**RESPONSE TO REQUEST FOR ADDITIONAL INFORMATION
SSD-11429726 – EDEN STREET COMMUNITIES PLUS**

This letter has been prepared by Ethos Urban on behalf of Arncliffe Eden Property Pty Ltd in response to the Request for Additional Information (RFI) issued by the Department of Planning and Environment (DPE) for SSD-11429726 dated 23 May 2022. This letter should be read with reference to the following appended documentation:

4 GFA DIAGRAM - LEVEL 18 (TOWER C LEVEL 17)
1 : 600

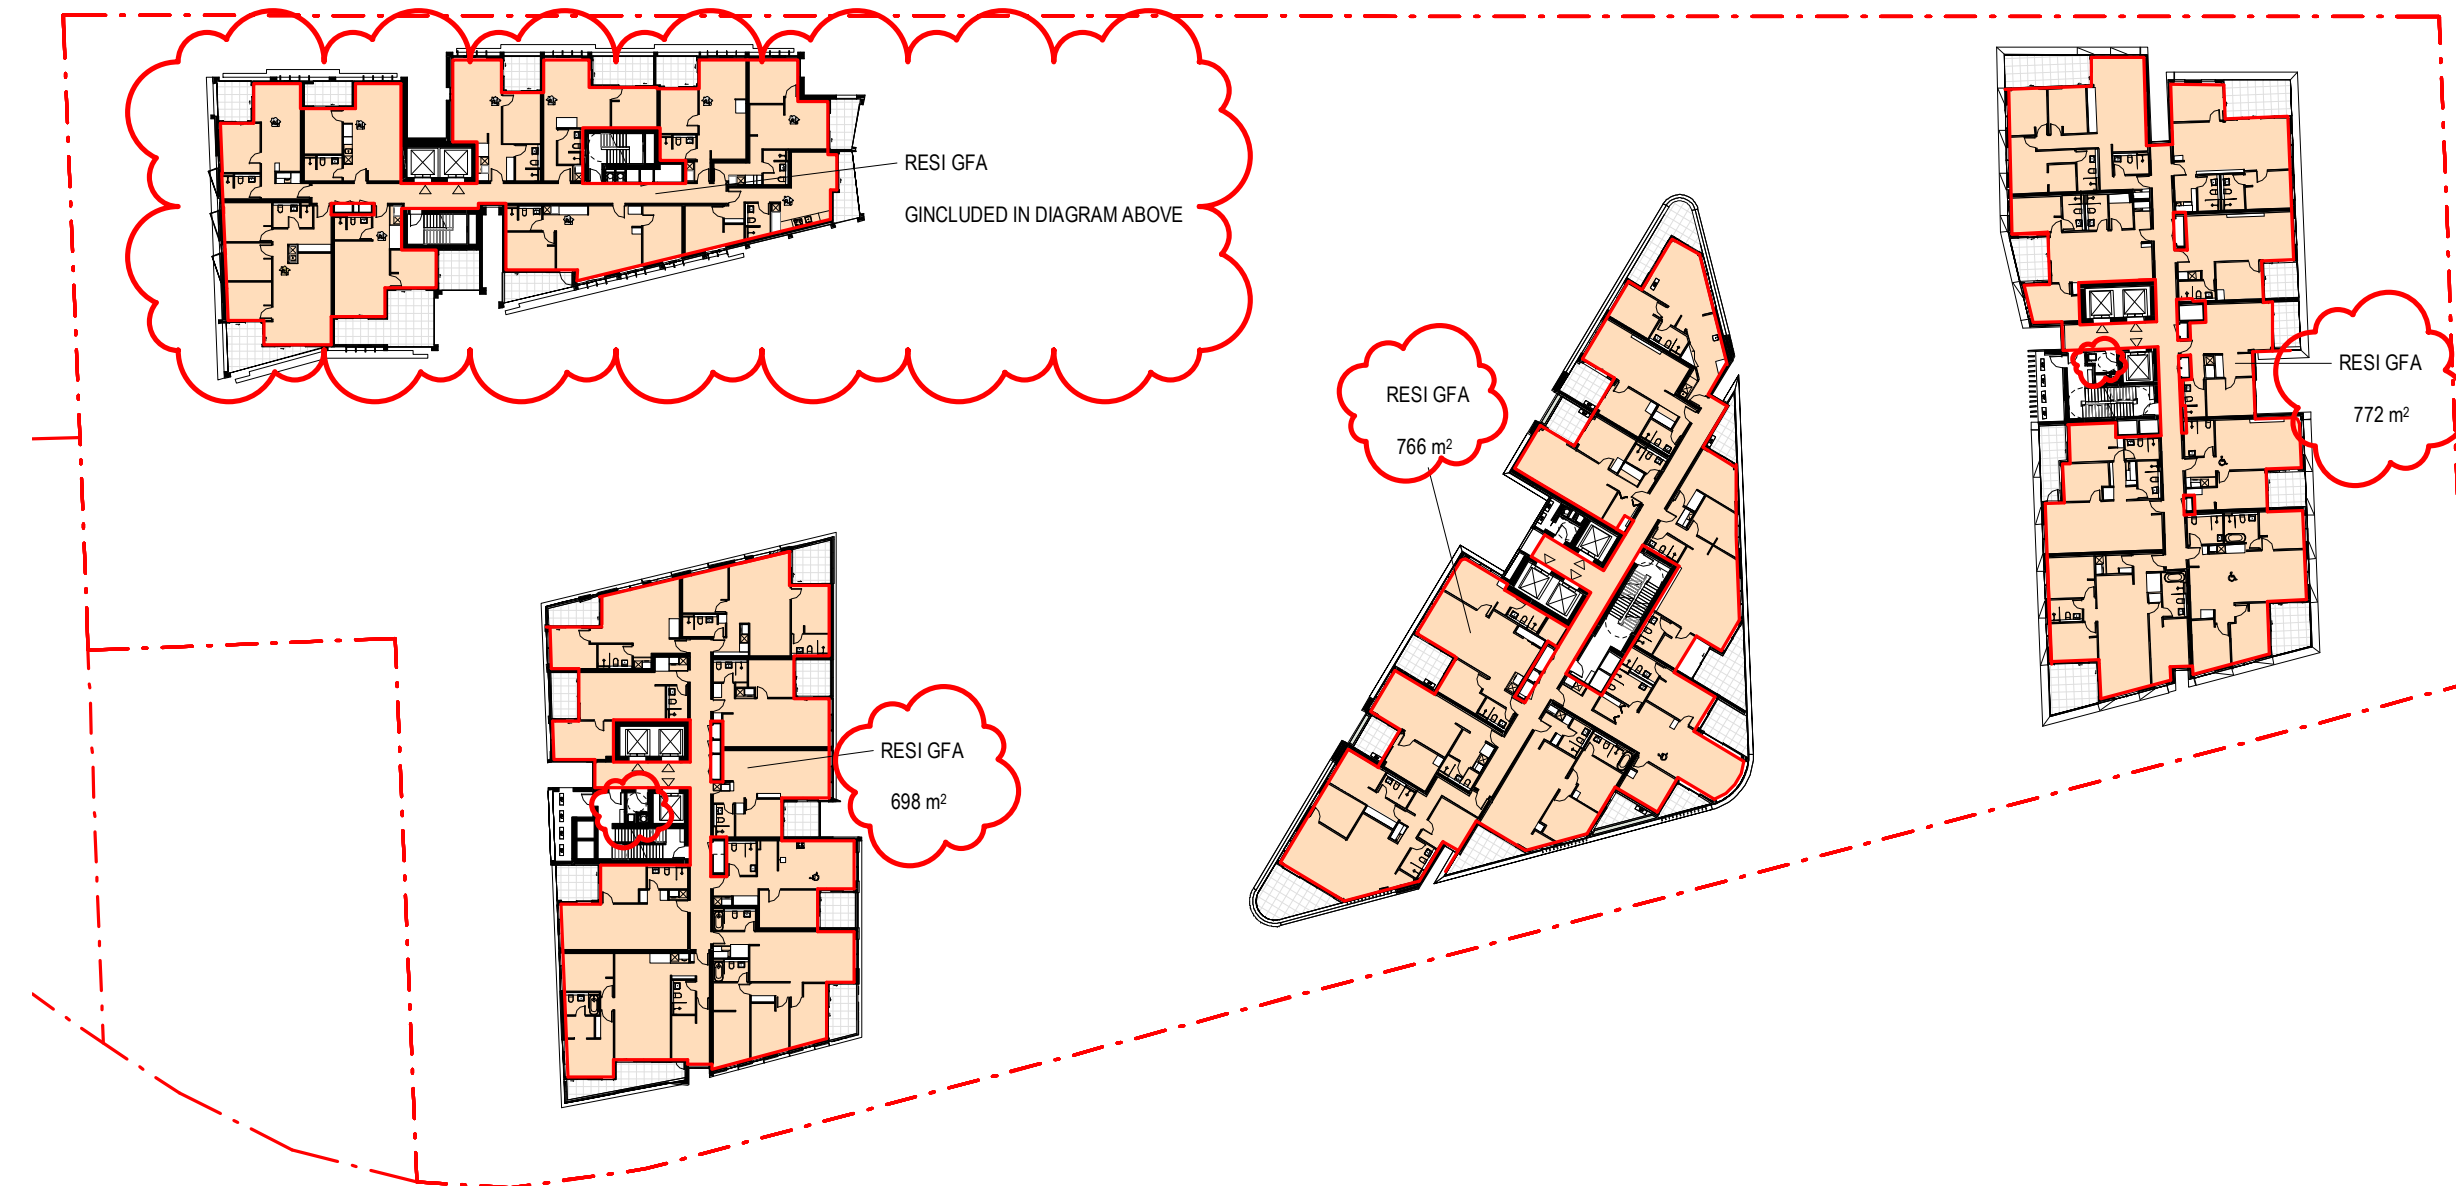
<p>7. Update the development summary table on drawing DA 0000 F to include wintergardens in the total GFA and FSR calculations.</p>	<p>Wintergardens have been included in GFA and FSR calculations.</p>
<p>8. Update the key on Drawing DA4101 to show 889m² of wintergarden instead of 848m².</p>	<p>Drawing DA4101 in Attachment B has been updated to show the correct wintergarden GFA.</p>
